From: James Smith
Sent: 24 April 2013 15:56
To: [REDACTED]
Subject: 32 Tennyson Avenue, Rustington (our ref: R/68/13)

Drawing No.	TAR002	Rev. A
Scale	1:100 & 1:50 @ A2	
Date	July 2012	Drawn DPS

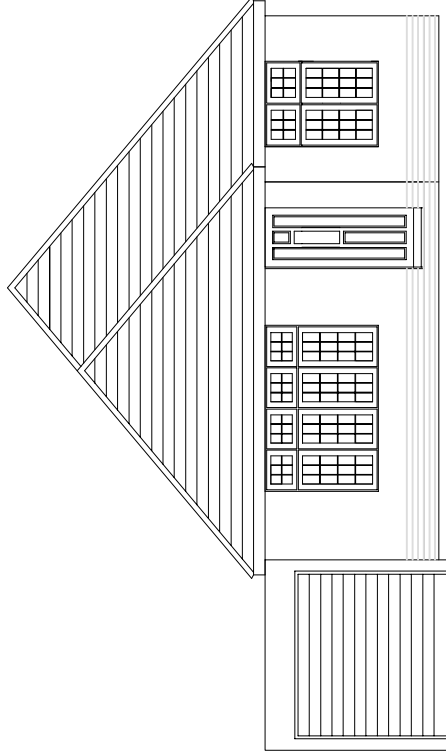
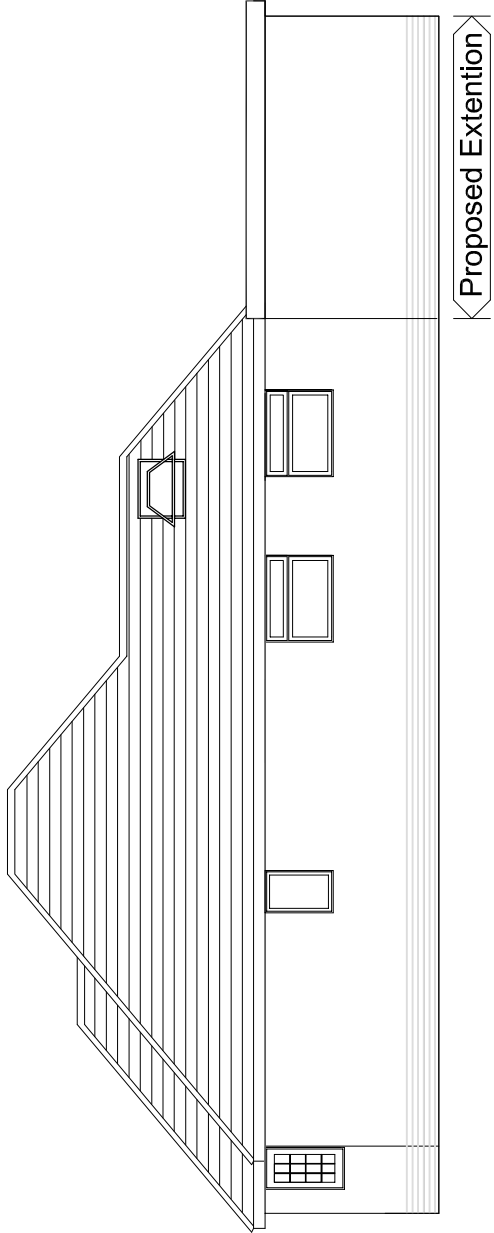
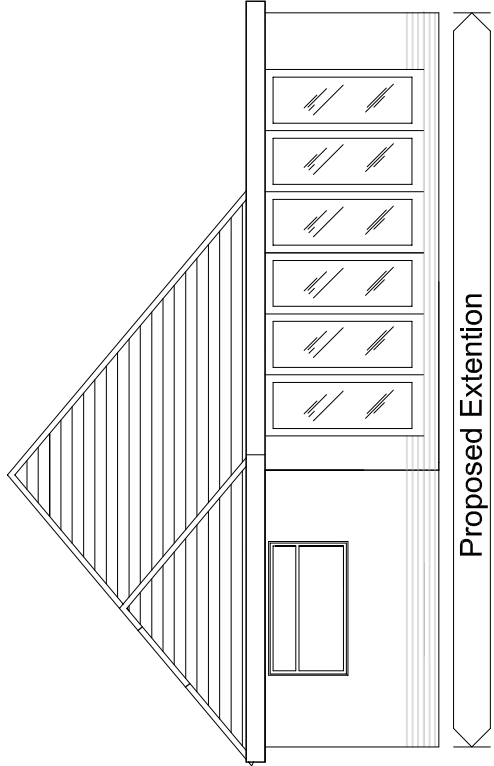
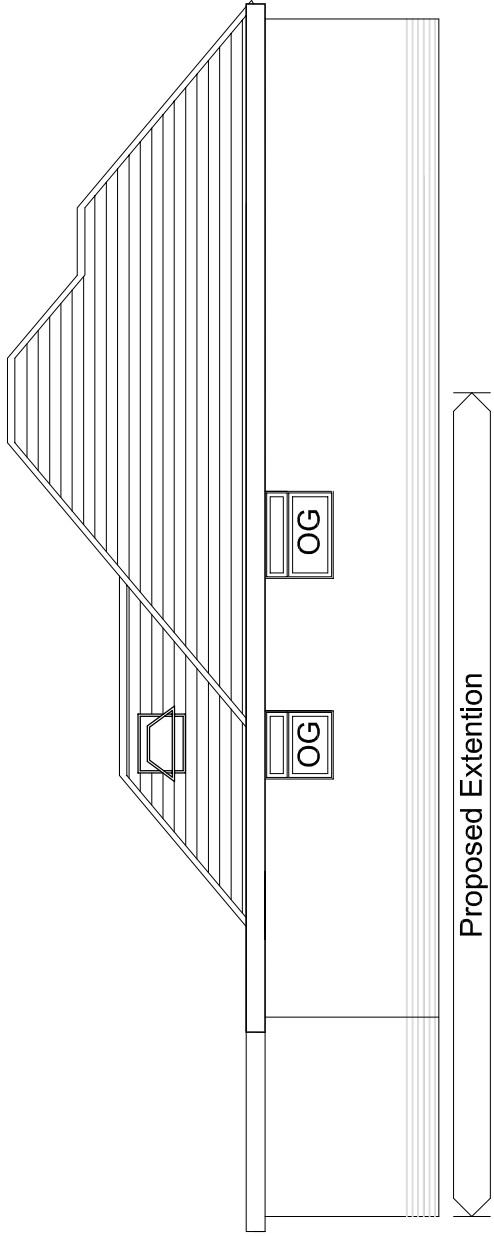
Thank you for the help in contacting Mrs Barnard, have now carried out my site visit. I was writing to query an inconsistency that appears to be shown on the proposed elevation plans. The front elevation shows the garage roof to be kept at existing height but the side (southern) elevation shows the roof raised to be aligned with that of the proposed extension.

Could you please confirm if the roof over the existing garage is going to be raised?
